Dear Sirs

Application M/56/15/HH
31 Sea Way, Middleton-On-Sea, West Sussex, PO22 7RZ

ROOF PLAN
1.100

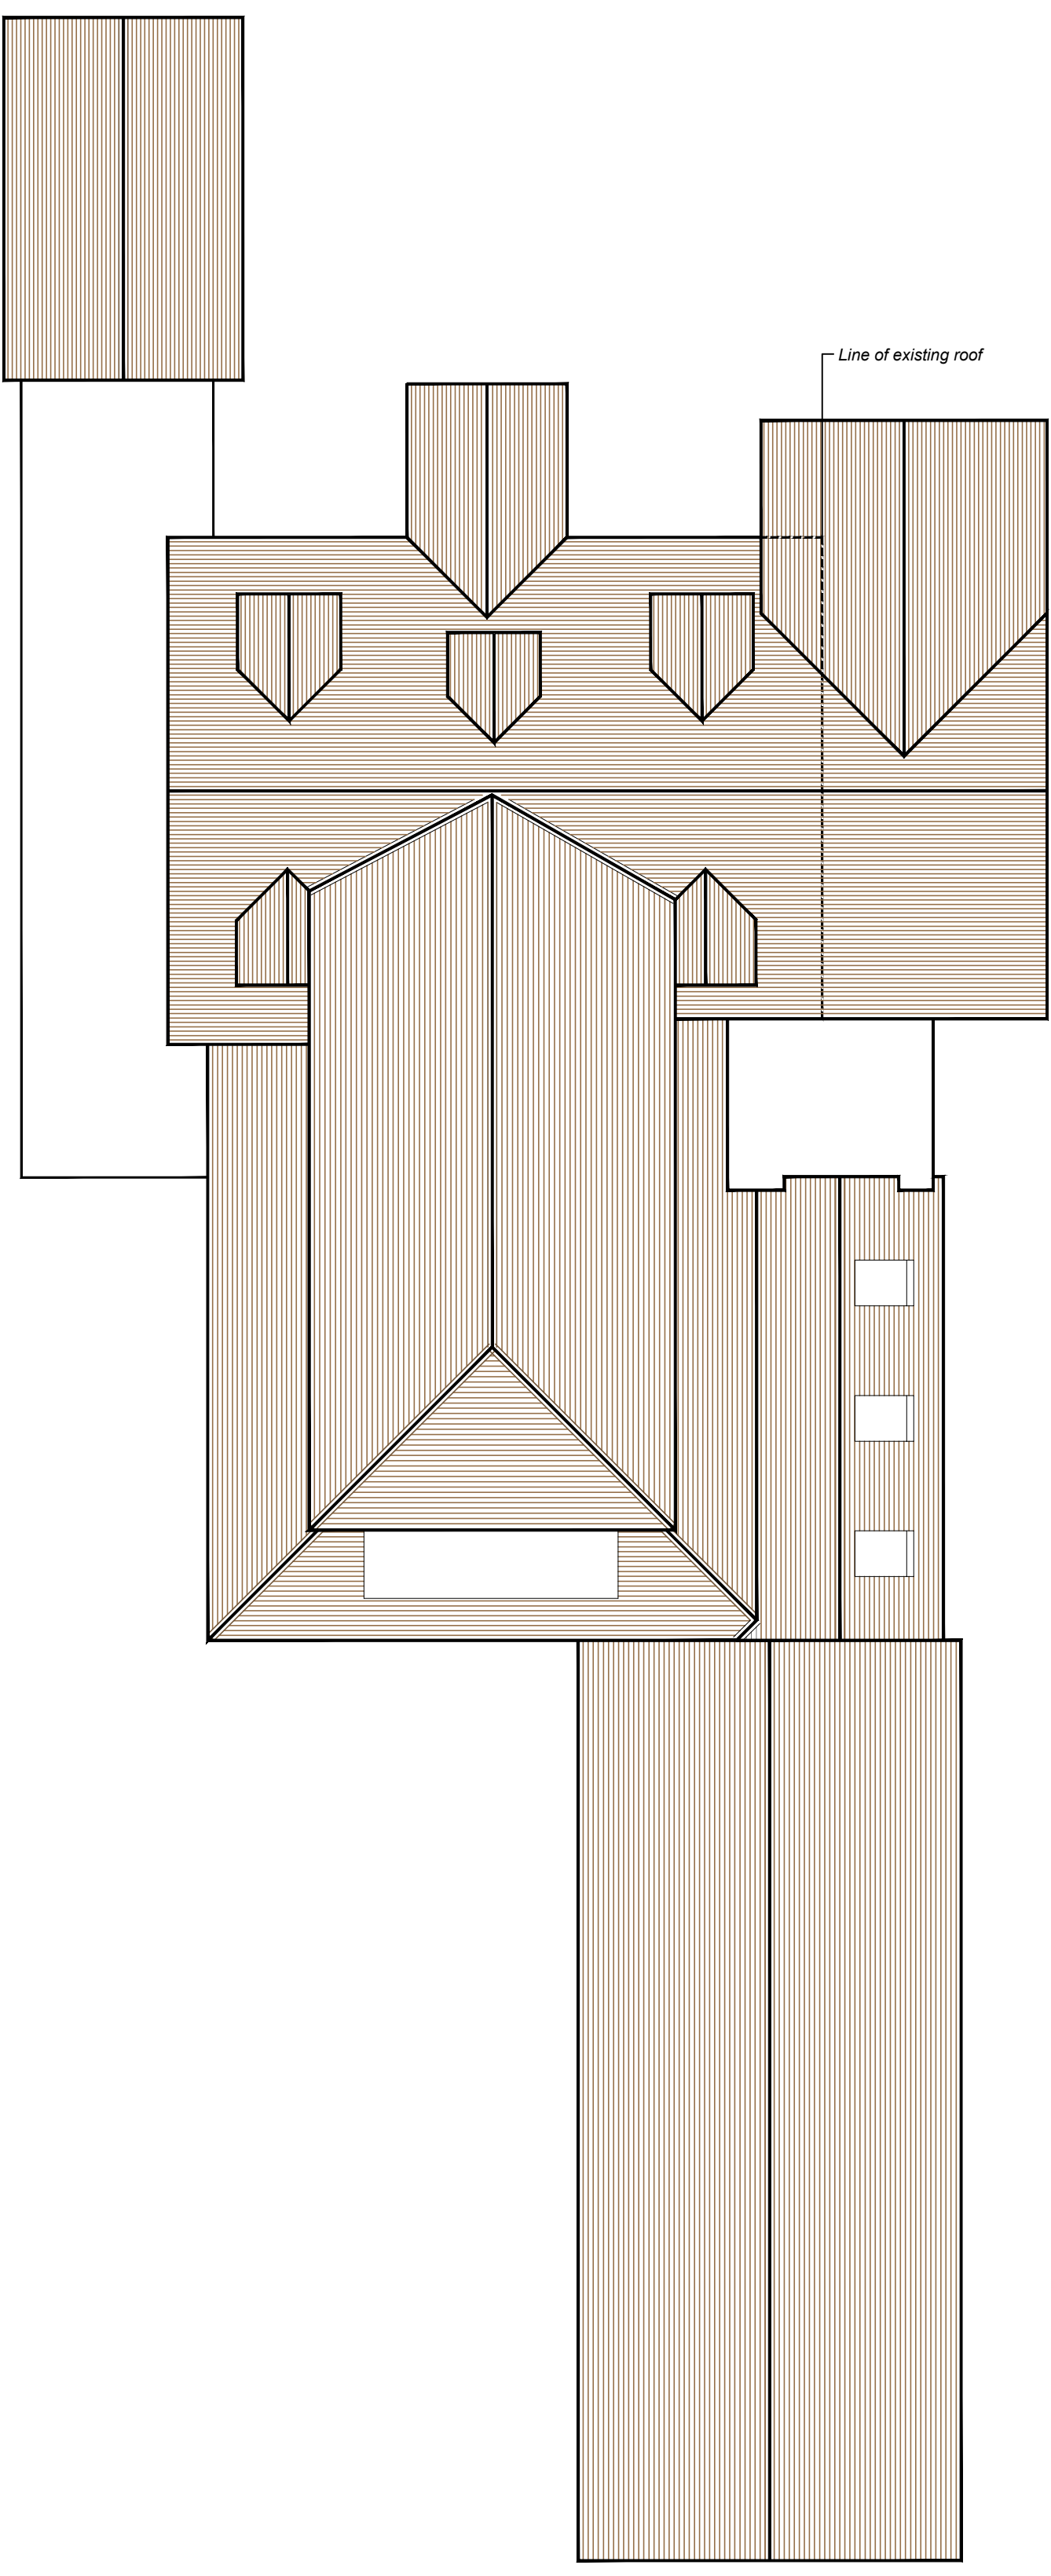
The Design and Access Statement in section *4.4 Amount*, states the ground floor footprint of the Main house is **208.7m²** and then states the proposed ground floor footprint will be **242.2m²**.

Planning applications are to be judged on an individual basis but also viewed against the previous developments on the site and it would appear that No. 31 has been evolving vertically from bungalow to house and now horizontally to fill the site from each neighbour's boundary. This two storey side extension will dominate our house overshadowing our front windows and entrance foyer particularly the evening sunlight.

The 1m side access does not take into consideration the 0.3m overhang to the verge of the roof creating an overbearing structure right on the boundary and again reduce the space between properties. There is also the loss of privacy and overlooking from the new first floor dormer window to the 5th bedroom which looks directly down into our front facing window. The loss of light particularly to this window will be dramatic and we will be assessing any “rights of lights” issues separately.

The proposed swimming pool extension has a ridge height of **4.47m** and a length of **15.5m** making it both extremely high and long and very bulky. With the proposed other extensions and proposed garage, if approved, nearly **48m** of my west boundary will have a structure built up against it, that is approximately 70%. The small south west section of our garden
